16 December 2021

SSD 25725029 – Construction and Operation of a Warehouse and Manufacturing Facility at Proposed Lot 12 – 657-769 Mamre Rod, Kemps Creek

LANDSCAPE CONCEPT PLAN

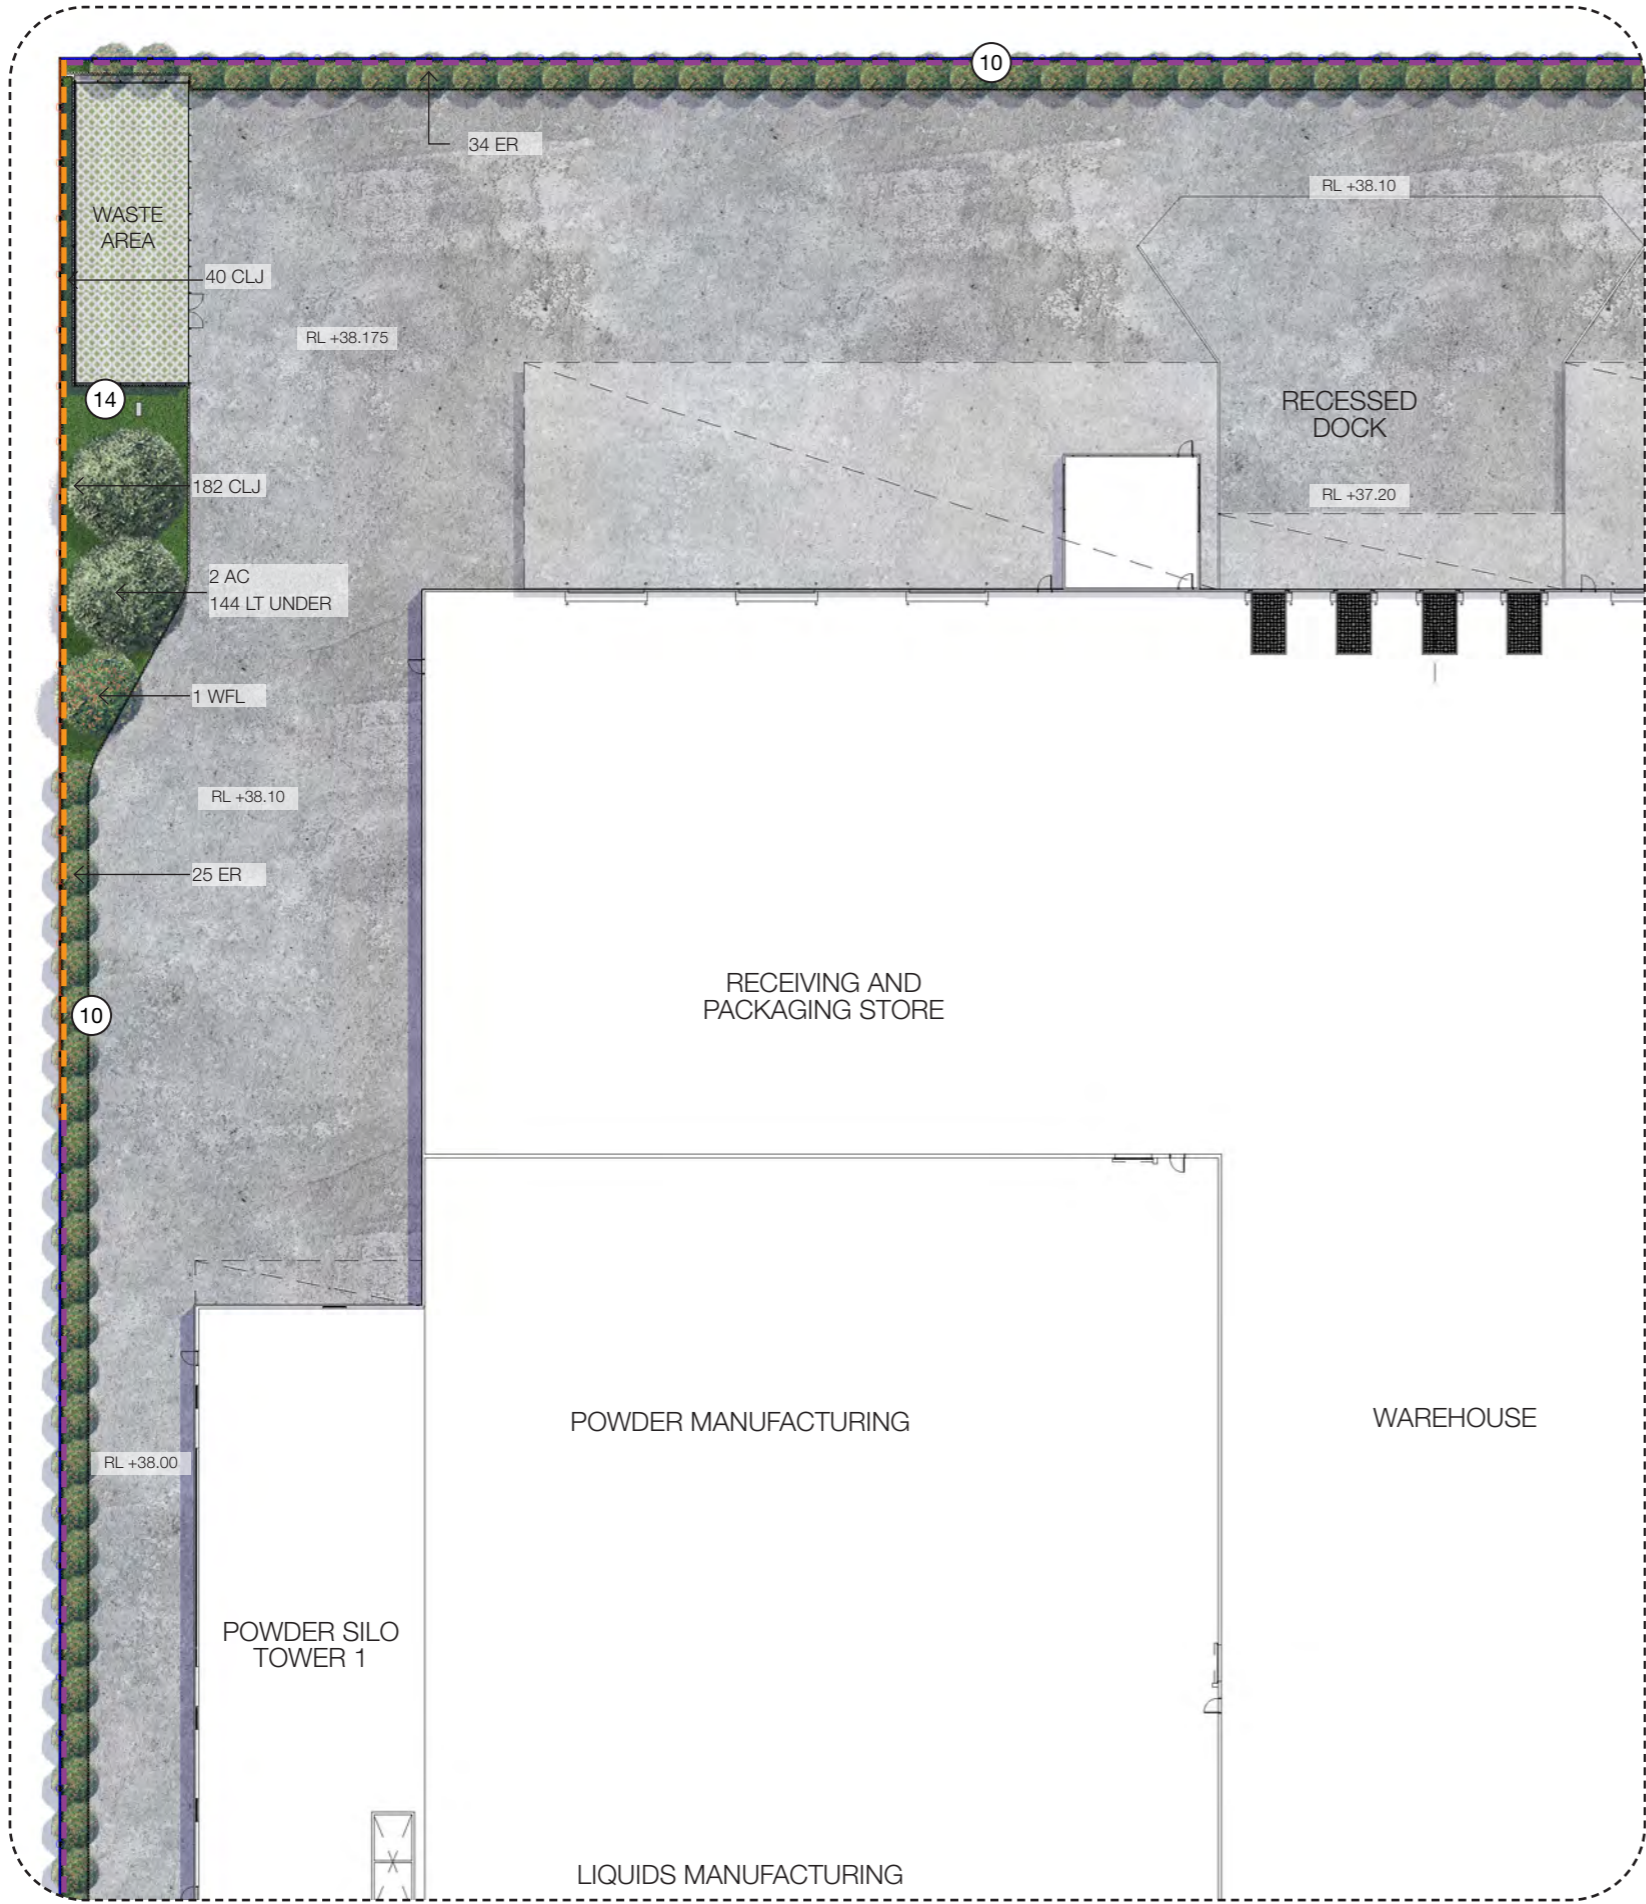
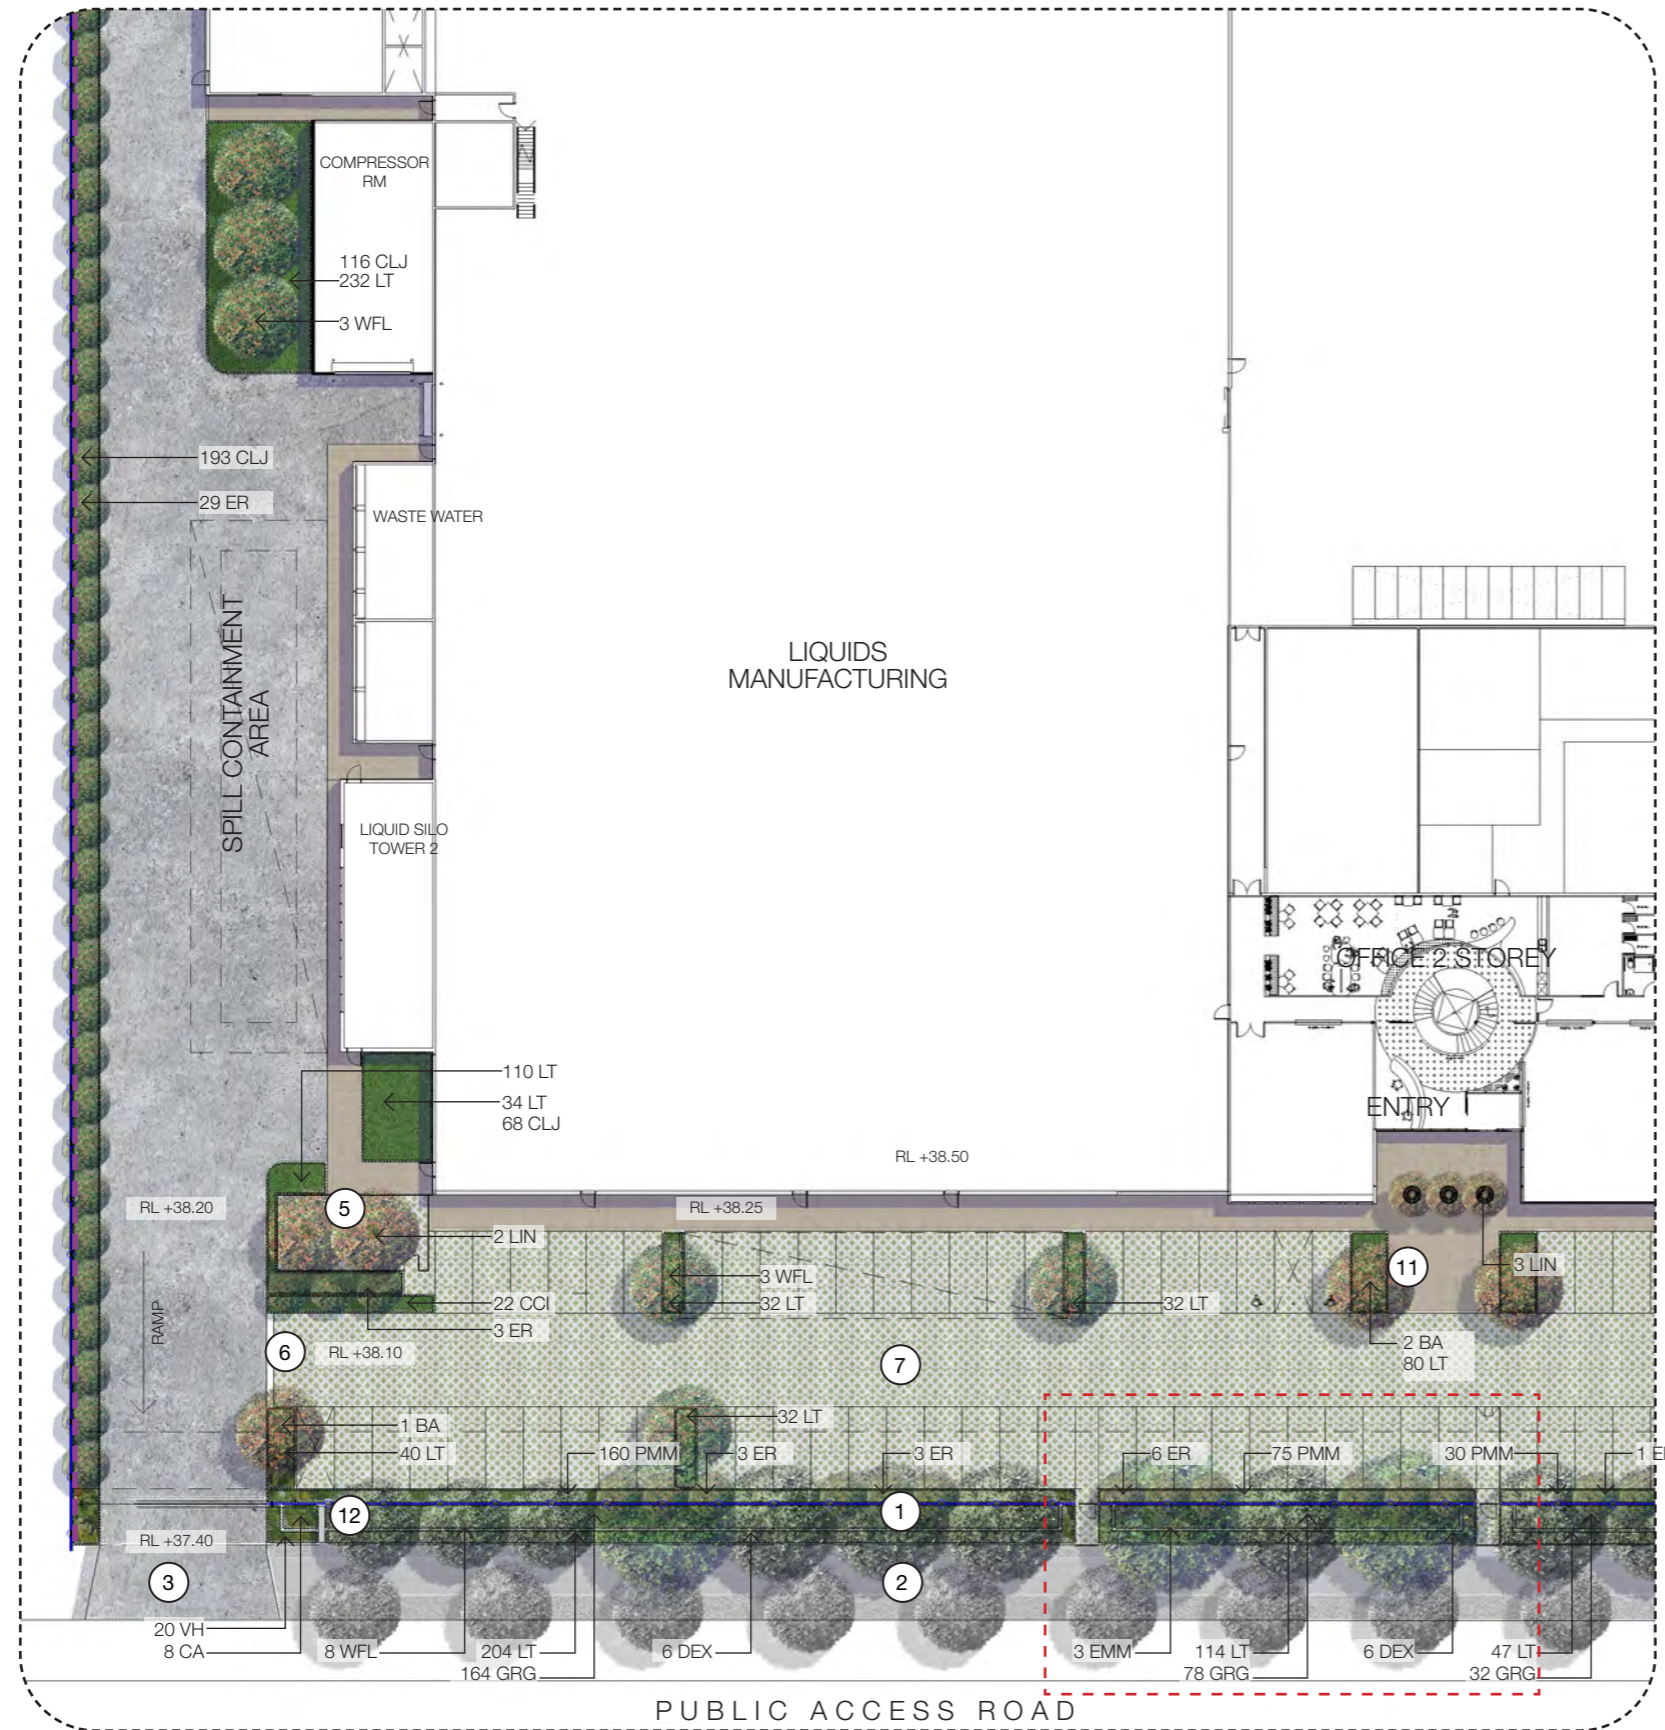
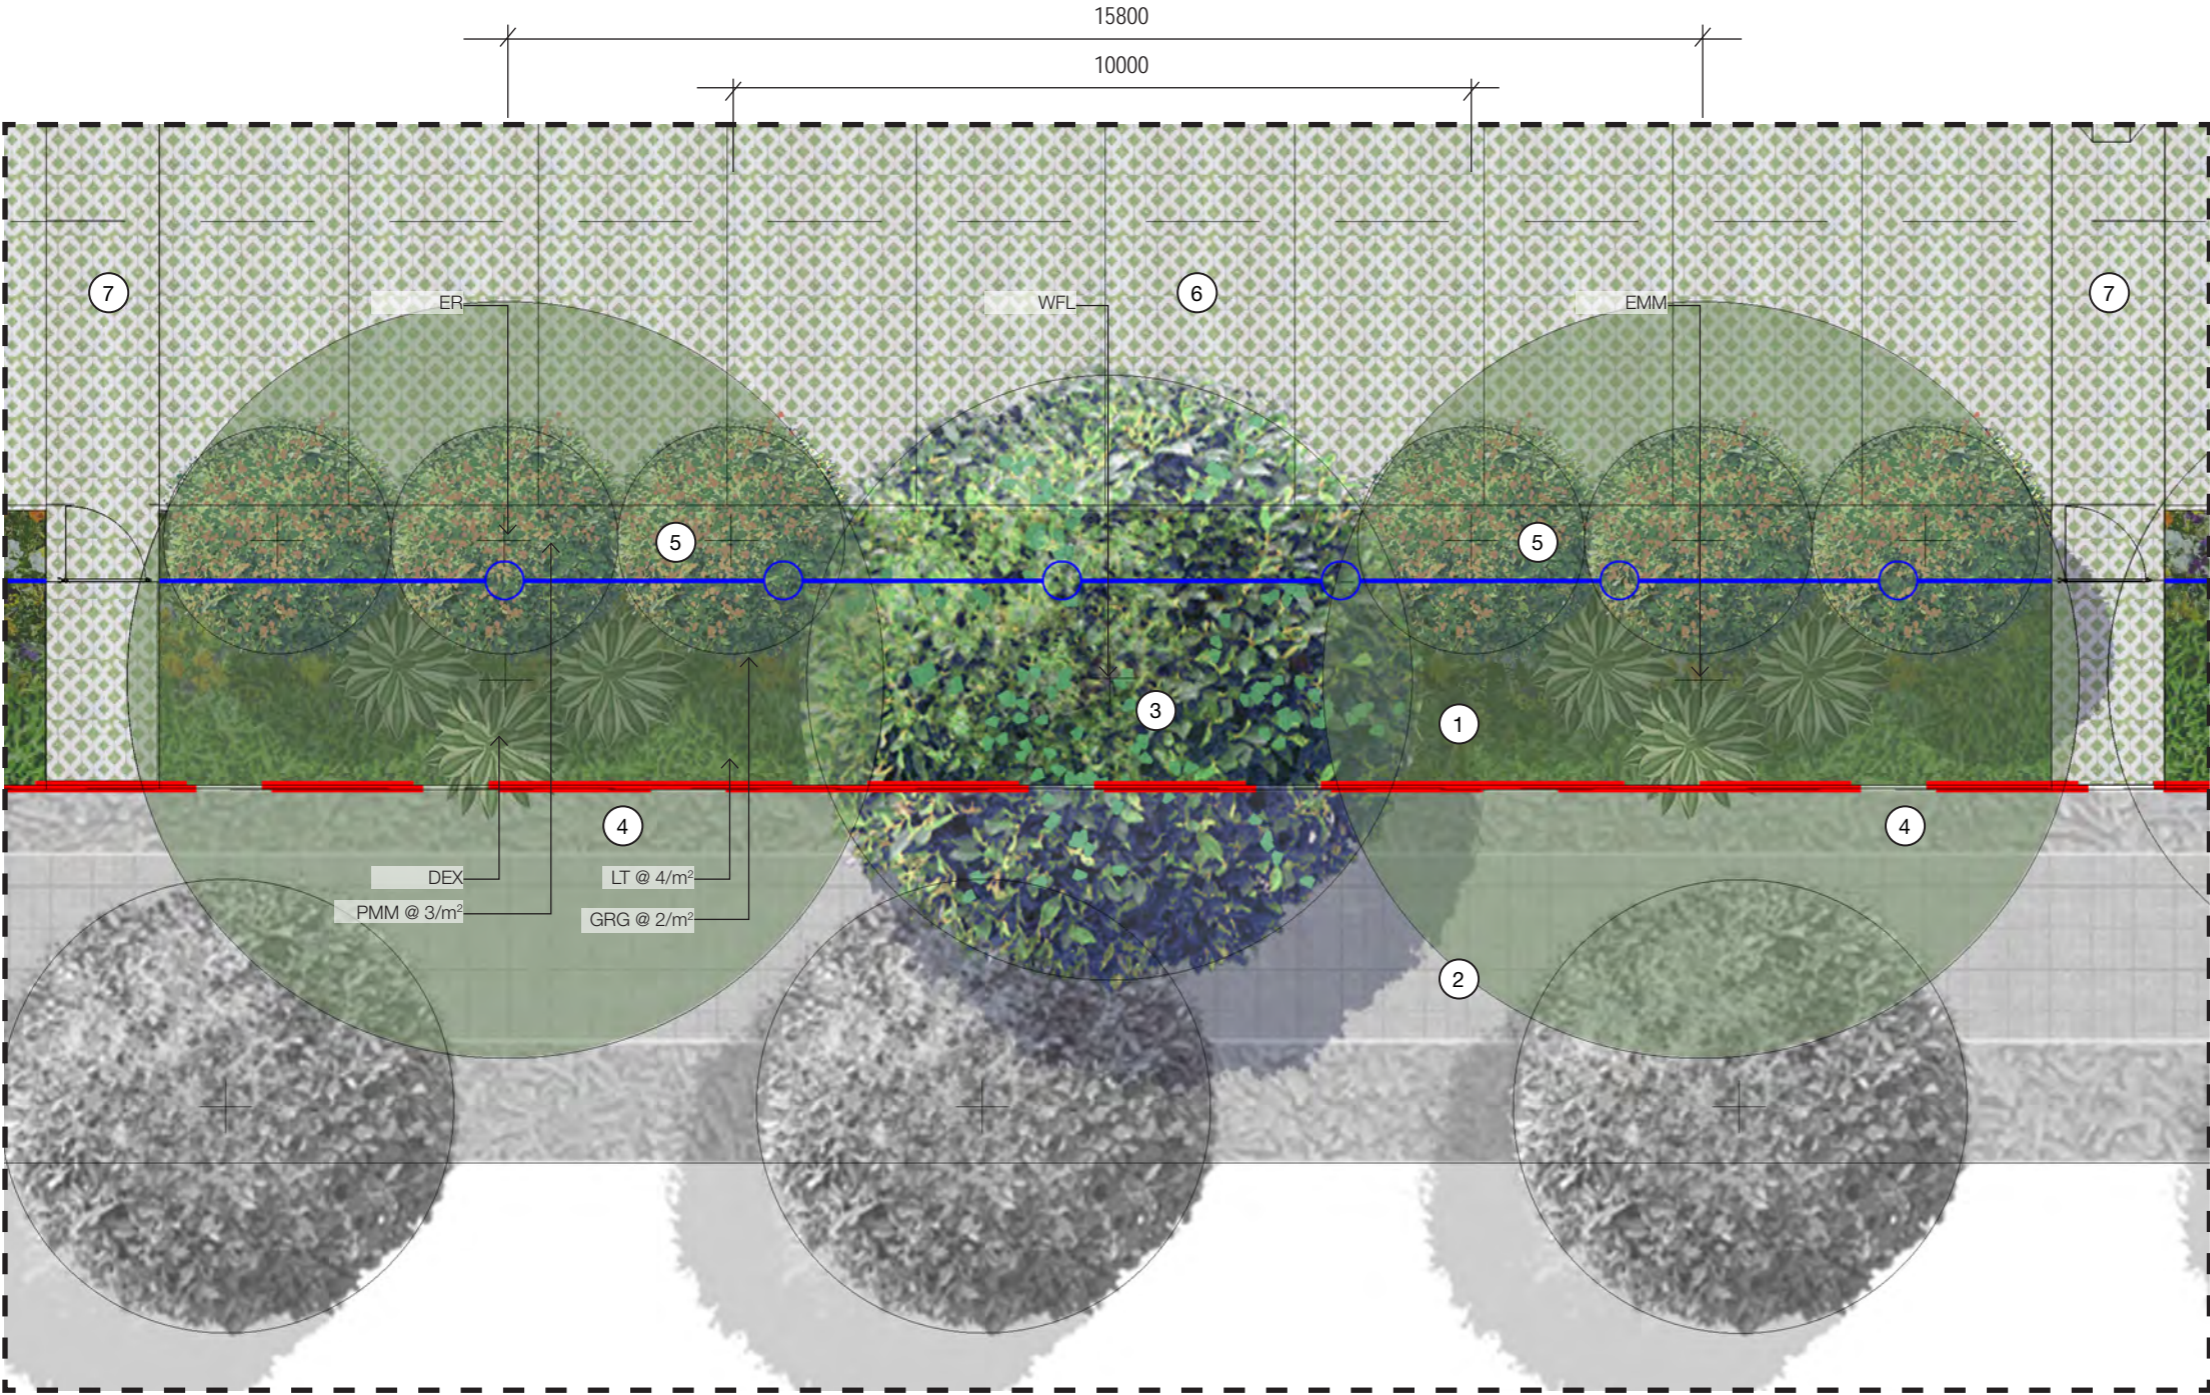
However, the Landscape Plans include species that are known to attract birds and flying foxes, in particular the proposed Eucalypts, Angophoras and Figs. WSA therefore requests the proposed species be reviewed and reference made to Appendix B of the Draft Phase 2 Western Sydney Aerotropolis Development Control Plan for alternate species.
